REQUEST

Current Zoning: N1-B (Neighborhood 1 – B)
Proposed Zoning: N2-A(CD) (Neighborhood 2 – A, conditional)

Approximately 3.726 acres located along the south side of The Plaza, east of Aintree Road, and west of Lakedell Drive.

The petition proposes to allow the development of multi-family attached residential units on parcels developed with one single family home.

**RZ.01**

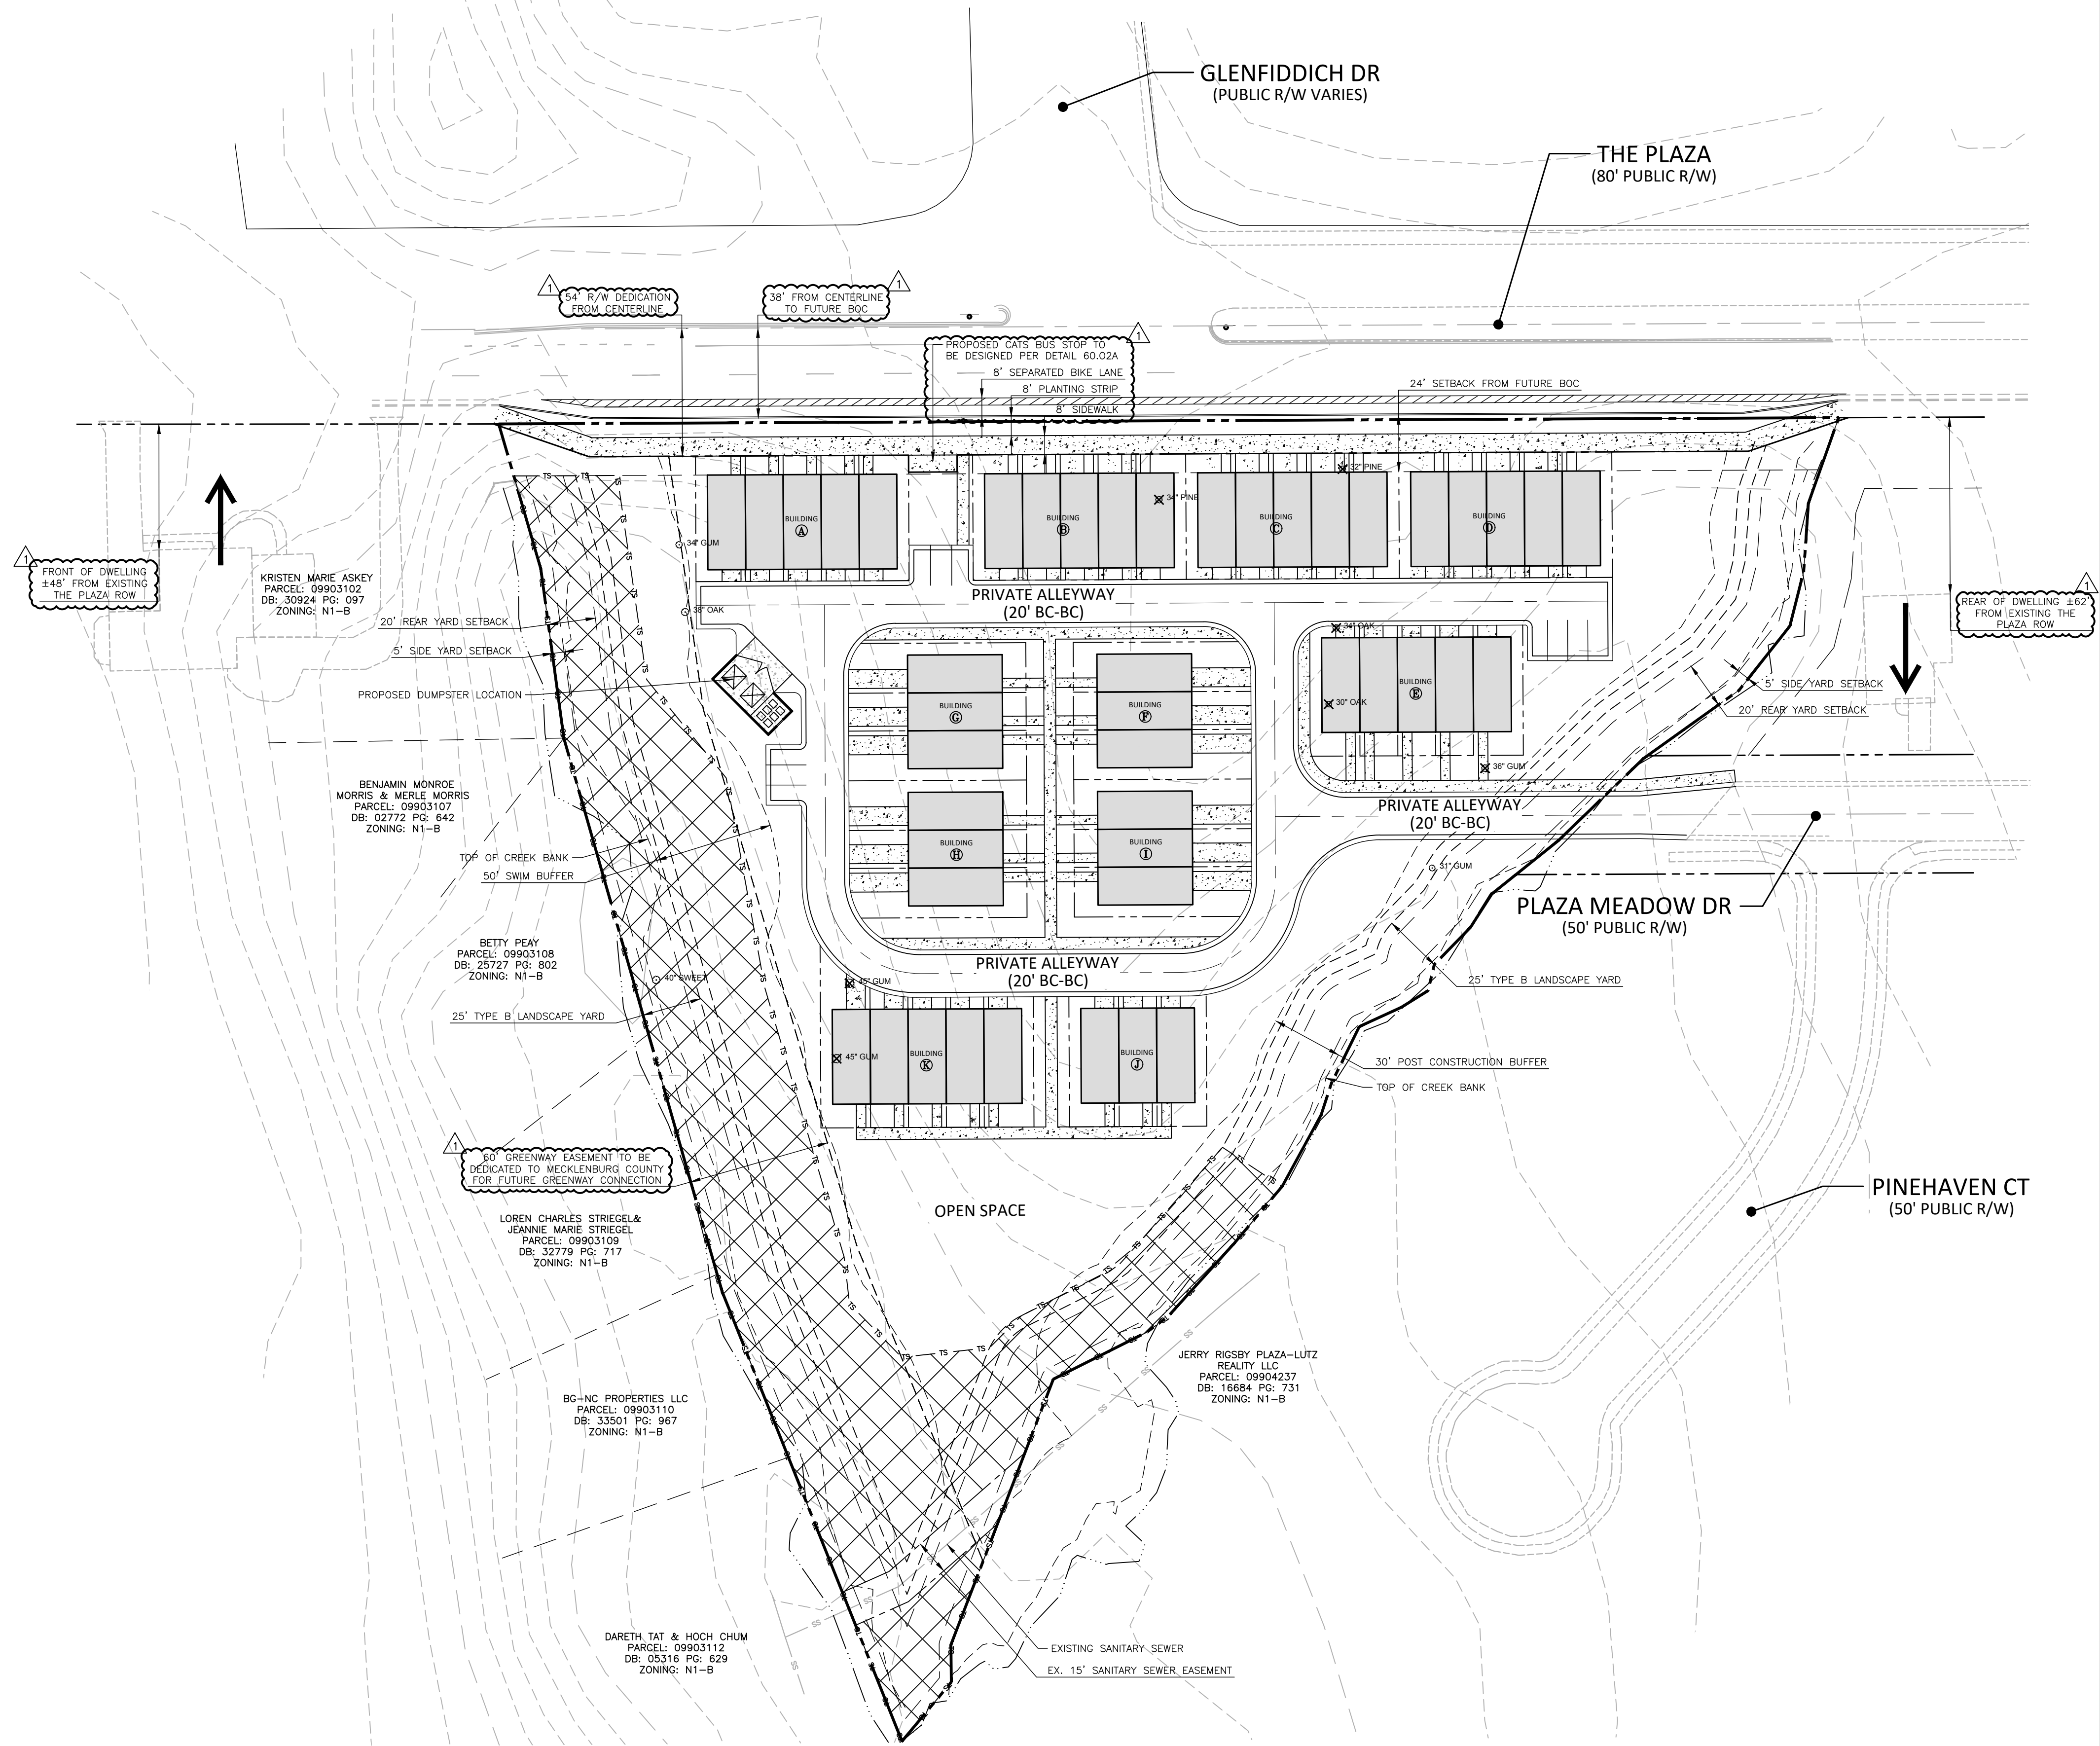
- ~~1. Provide a tree survey to Urban Forestry and show location of all existing heritage trees on the site plan.~~ **Addressed**
